Permit Number: 040050

This is to certify that Mks Development Inc /Christopher J. Ballou Inc
has permission to Build New 1715 sq. Ft. single family colonial with 2 car garage
AT 64 Yale St (Lot #7) City of Portland 438 A006001

Permit No: 04-0050	Date Applied For: 01/20/2004	CBL: 438 A006001
------------------------------	--	----------------------------

Proposed Use: Build New 1715 sq. Ft. single family colonial with two car garage.	Proposed Project Description: Build New 1715 sq. Ft. single family colonial with two car garage.
--	--

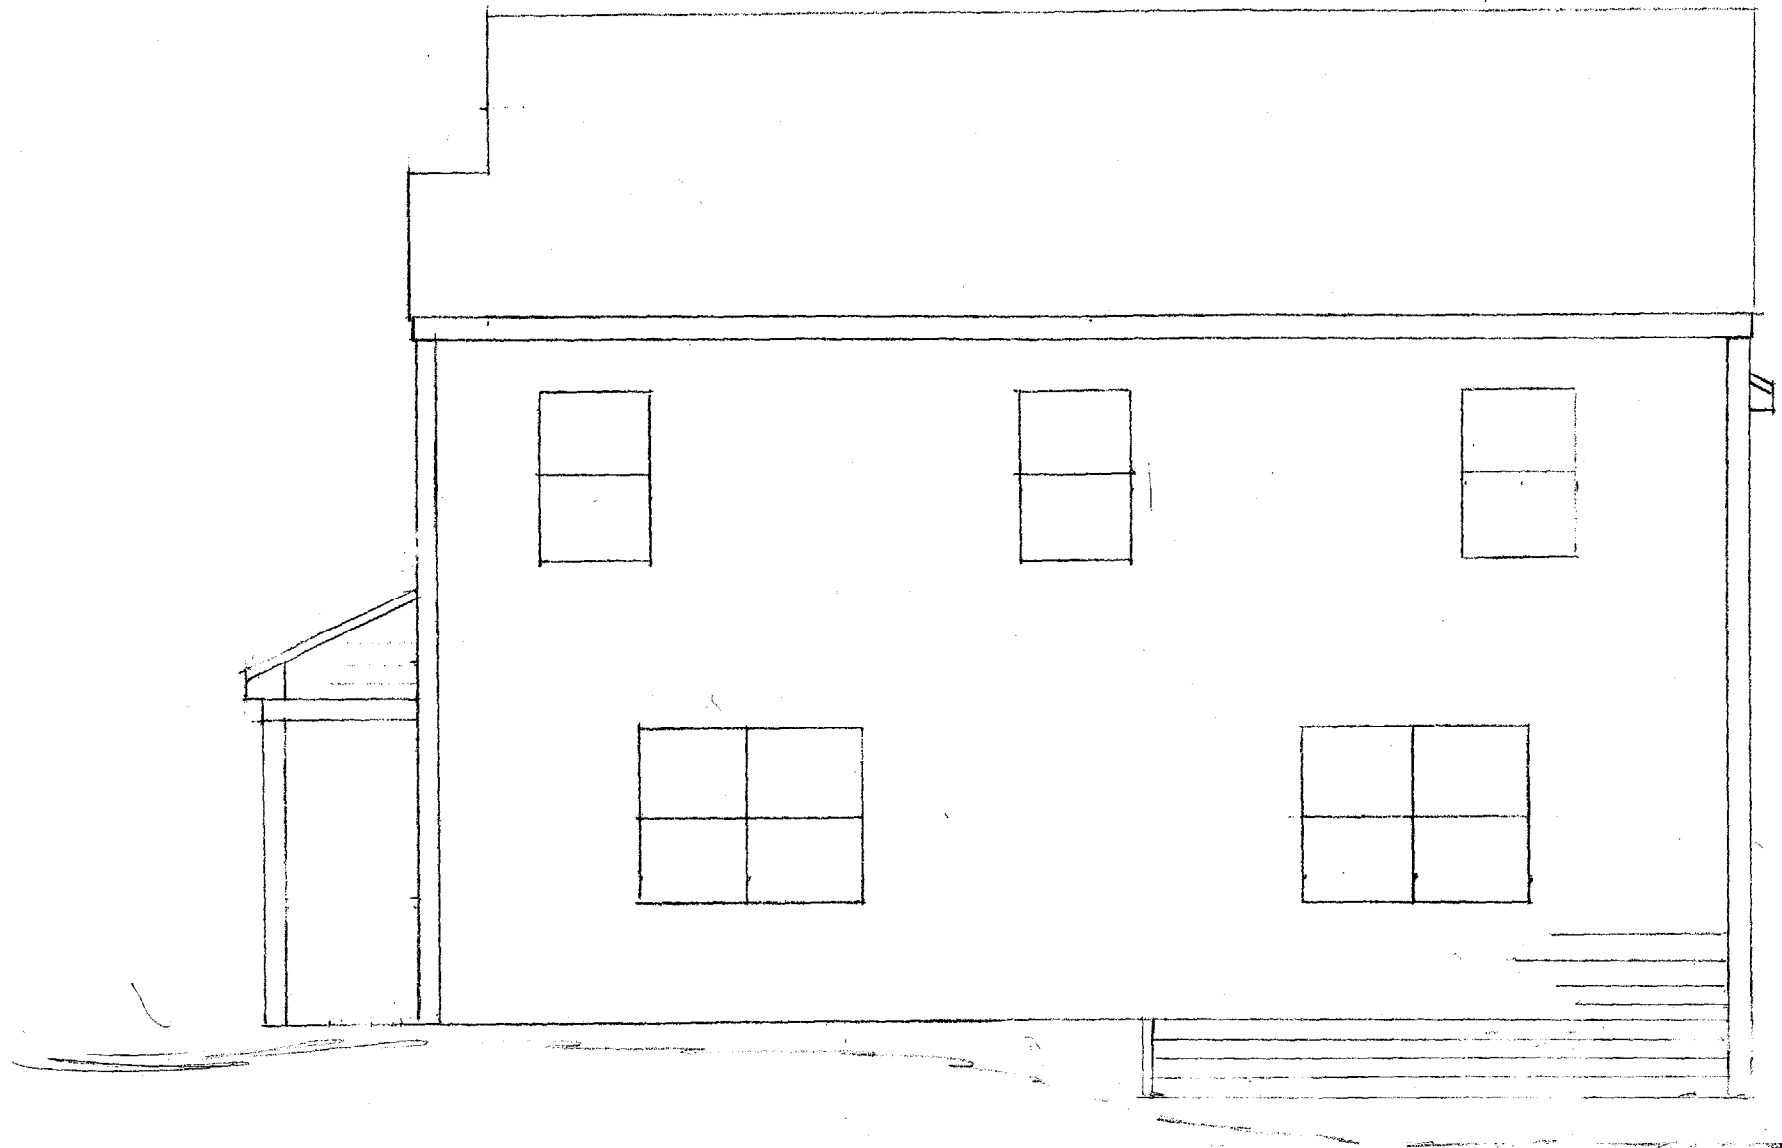
No Front Porch Detail

1st Floor Plan  
 CHRISTOPHER BALLARTE  
 7 TERRA WAY  
 FALMOUTH, ME 04105  
 1/4" = 1'-0"

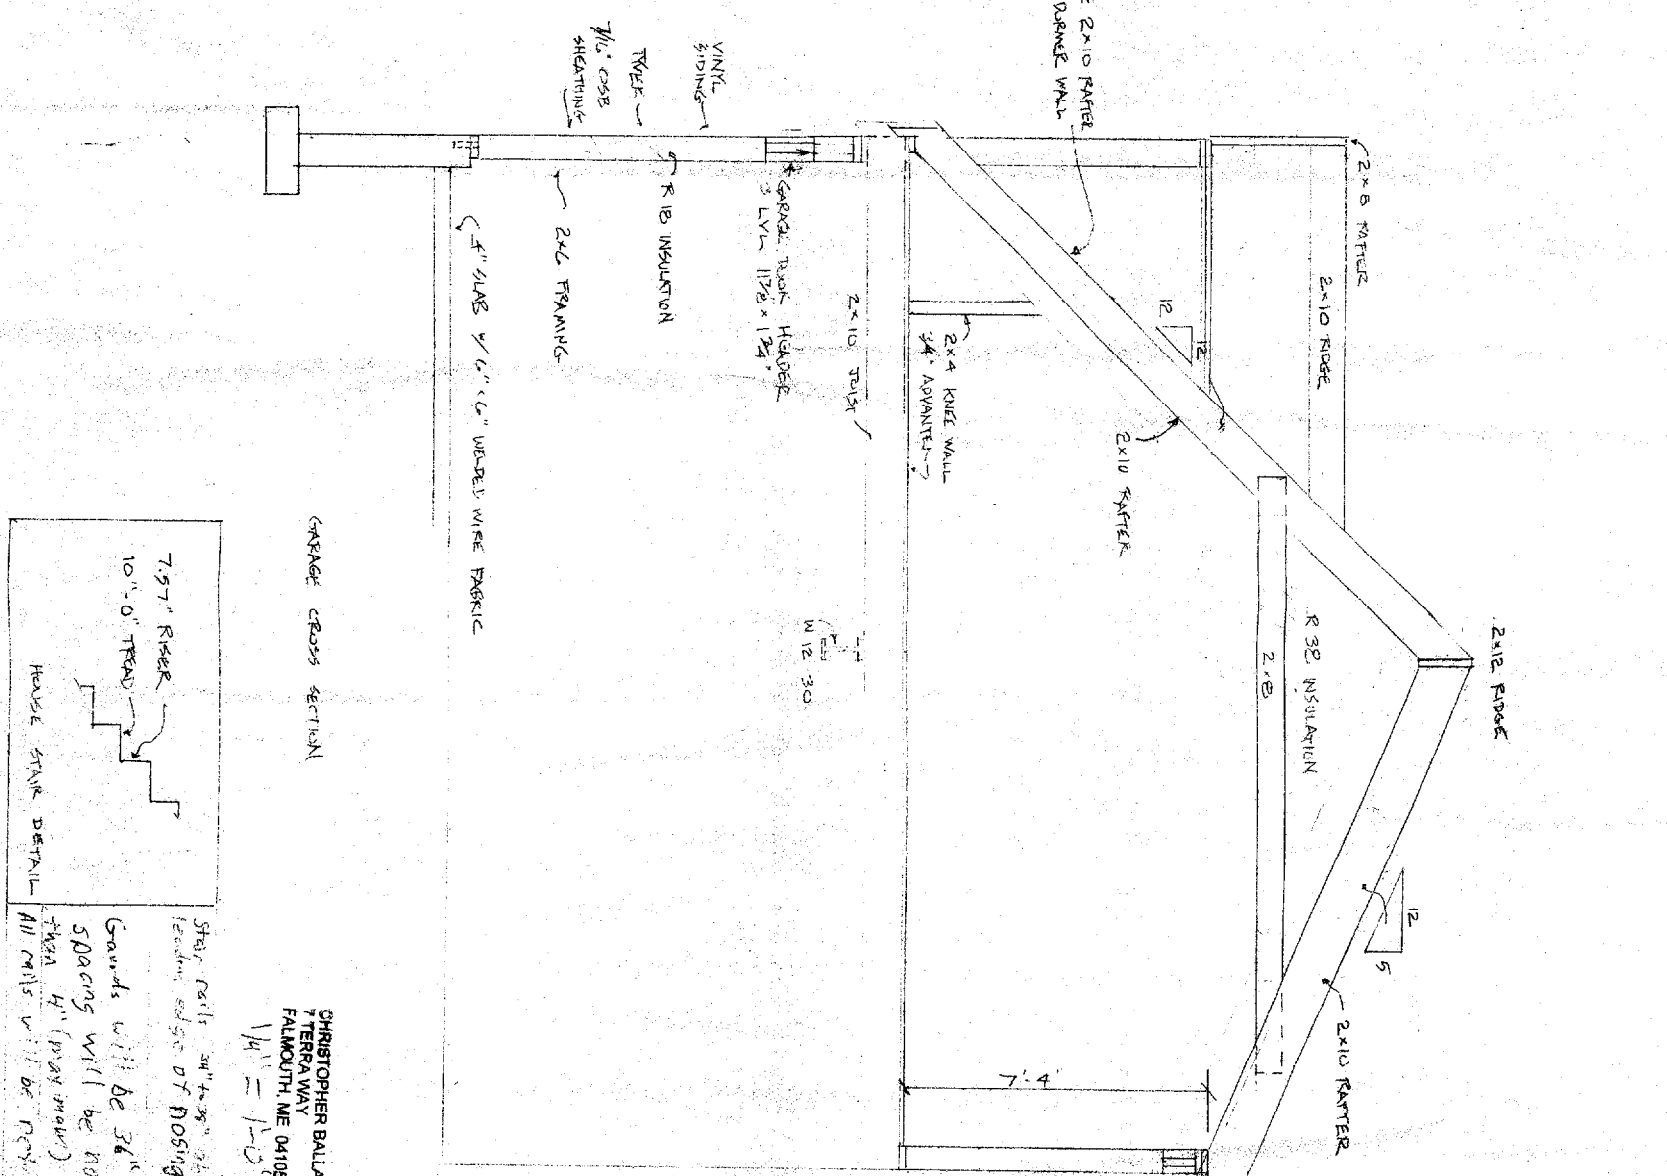
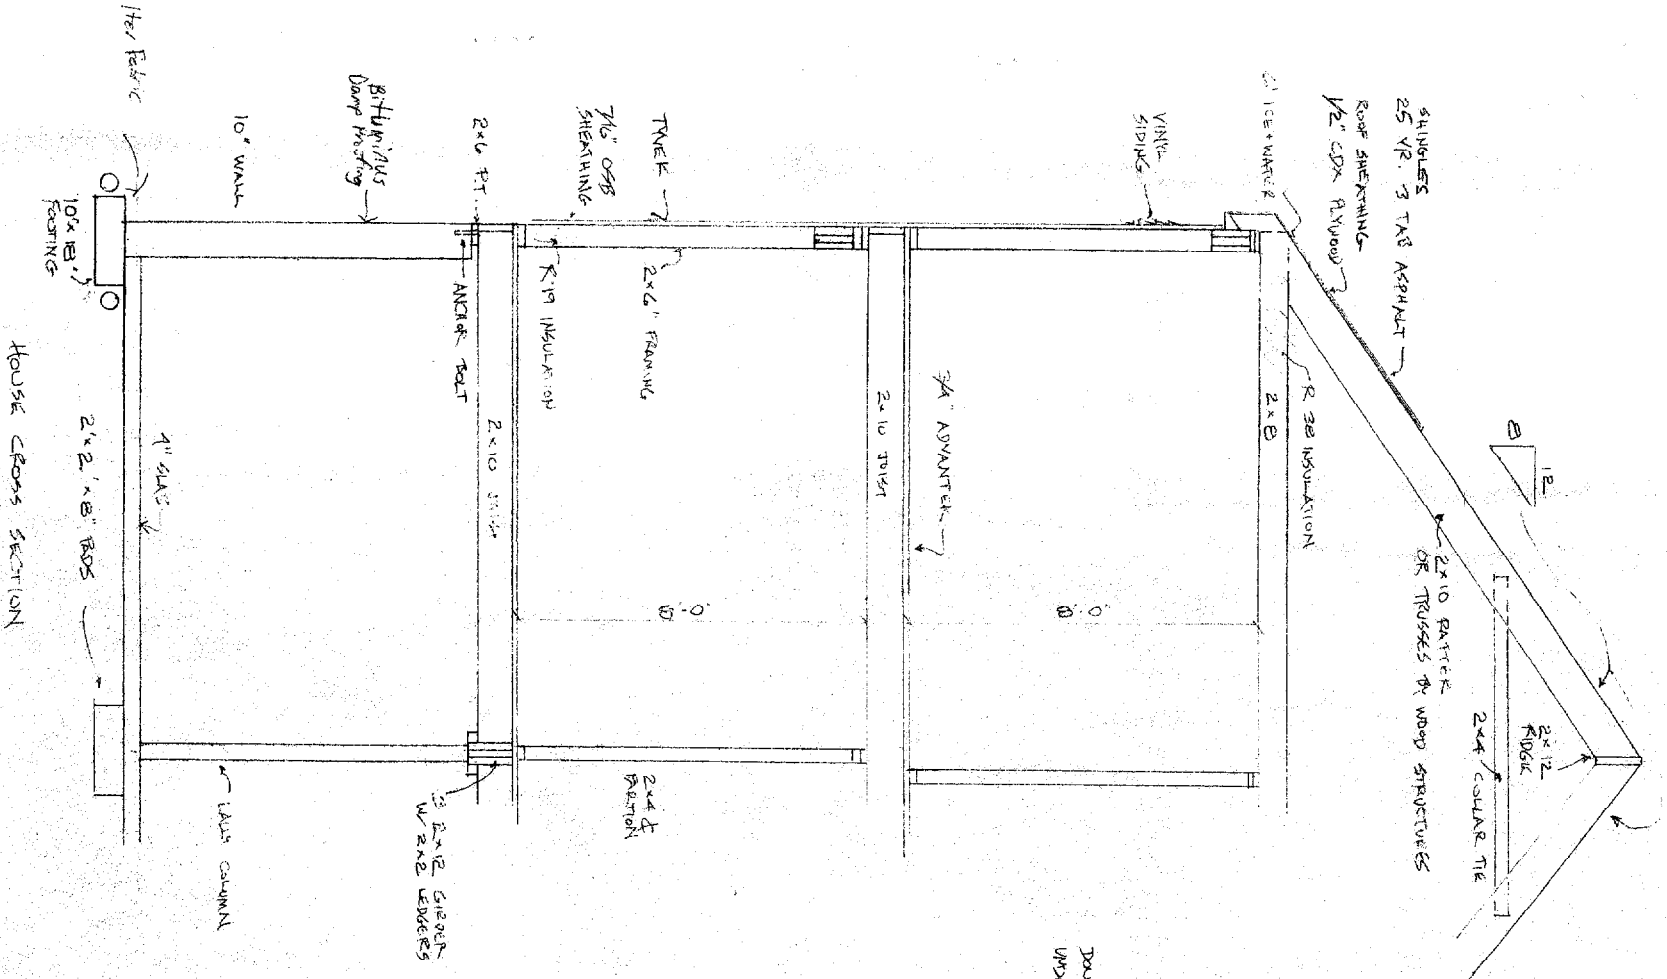
Header Schedule	Garage LVL 117/8" x 13/4 (3) Garage steel	need spec.
Type of Heating System	? direct vent	OK
Stairs		
Number of Stairways	2	OK
Interior	1	
Exterior		
Treads and Risers (Section 314)	10" tread 7.57 Riser	
Width	?	6'8"
Headroom	?	
Guardrails and Handrails (Section 315)	36" & 34" to 38" less than 4" returned	OK
Smoke Detectors Location and type/Interconnected	shows on plan	OK
Plan Reviewer Signature
